15 November 2018

RE: Newstan Colliery Modification 8 (DA 73-11-98) Response to Submissions

Set out below is Centennial Newstan's response to matters raised following public exhibition of the DA 73-11-98 Modification 8 Environmental Assessment (EA). A formal response to matters raised was requested by the Department of Planning and Environment (DP&E) in correspondence dated 26 October 2018.

**Figure 4:** Land ownership with Council-owned land shown in yellow

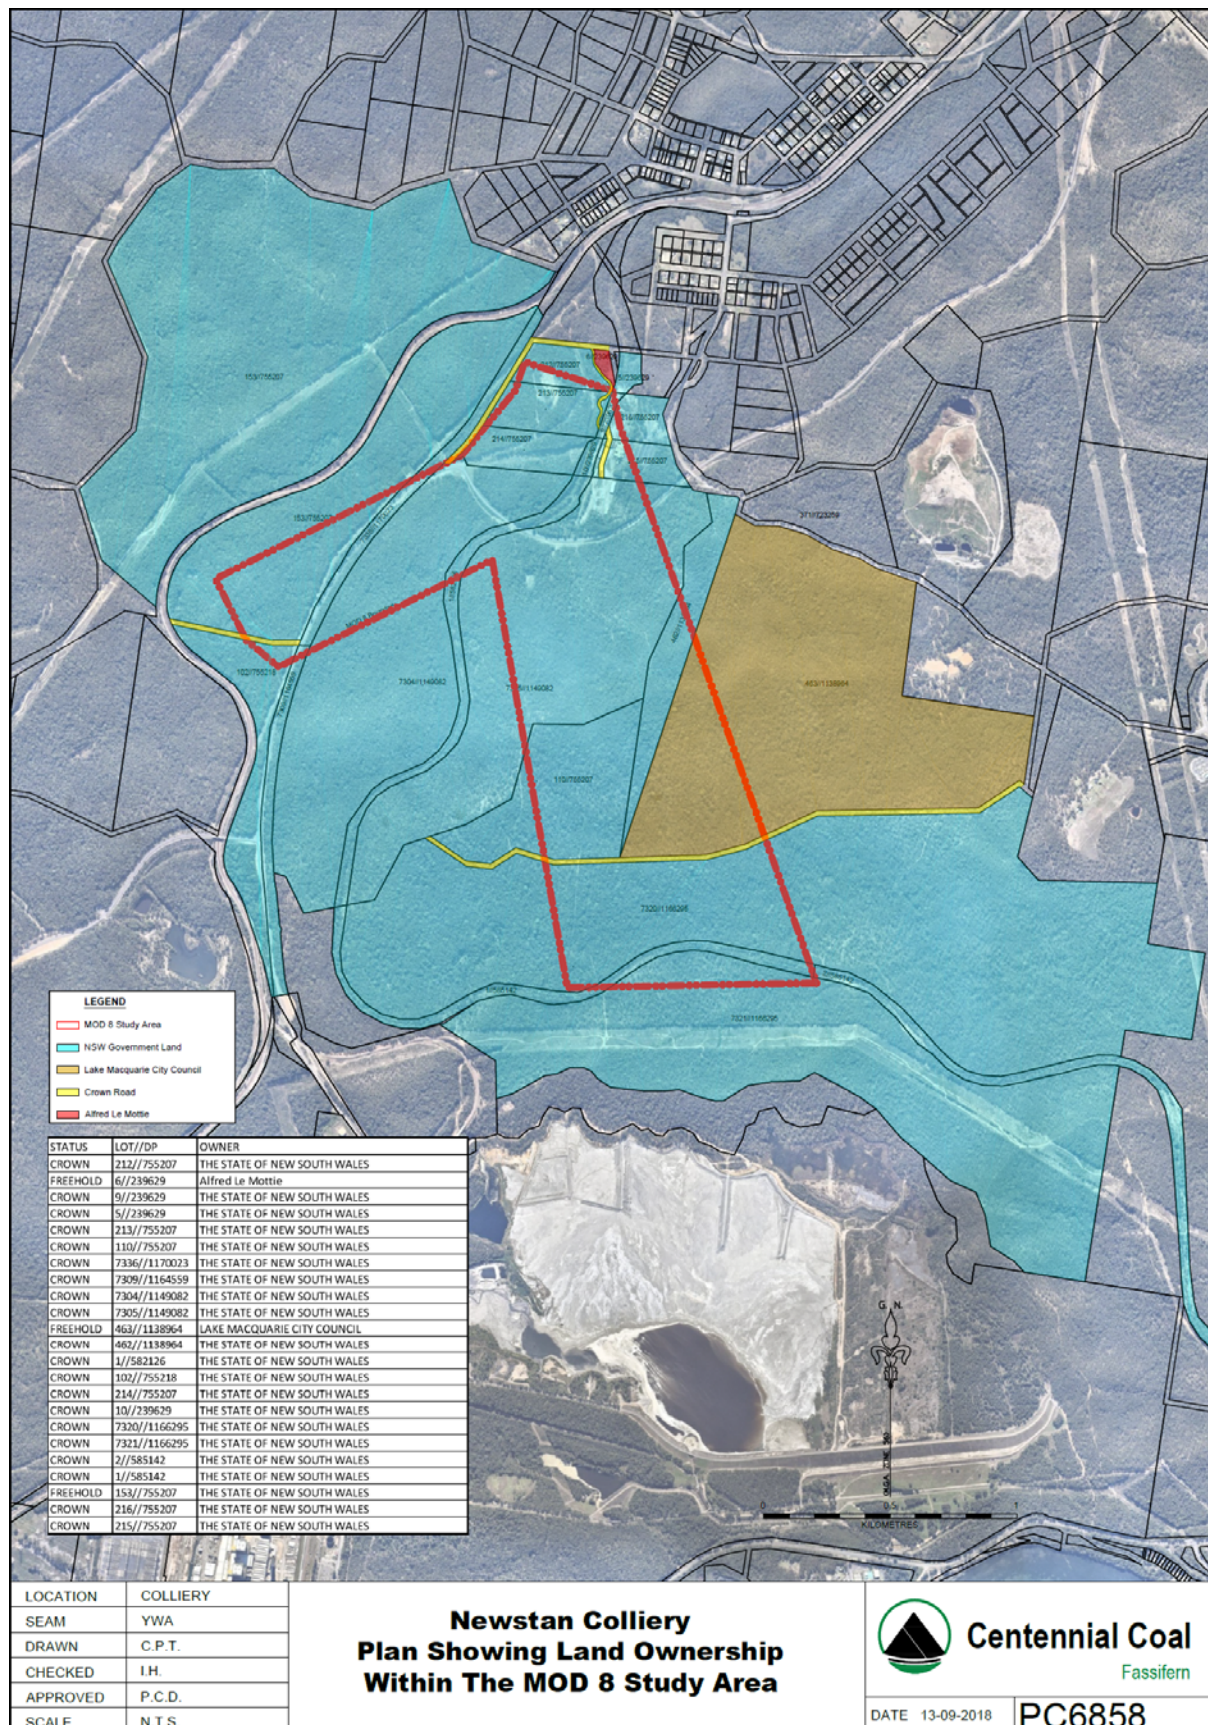
Submission matter: Land owned by Lake Macquarie City Council is partly within the project area. This land is described as Lot 463 DP 1138964 and is incorrectly shown in the environmental assessment (Figure 2-6) as being owned by the NSW Aboriginal Land Council. This land is known as the Awaba Biodiversity Conservation Area and is a biodiversity offset site managed for the protection of biodiversity in accordance with the Awaba Biodiversity Conservation Area – Plan of Management 2015. Council consulted with Centennial Coal in the preparation of this plan and Centennial Coal was made aware of the biodiversity significance of the site at that time.

Response: Centennial Newstan acknowledges this error on Figure 2-6 and has subsequently amended the figure. A copy is attached to this letter report as Attachment 2.
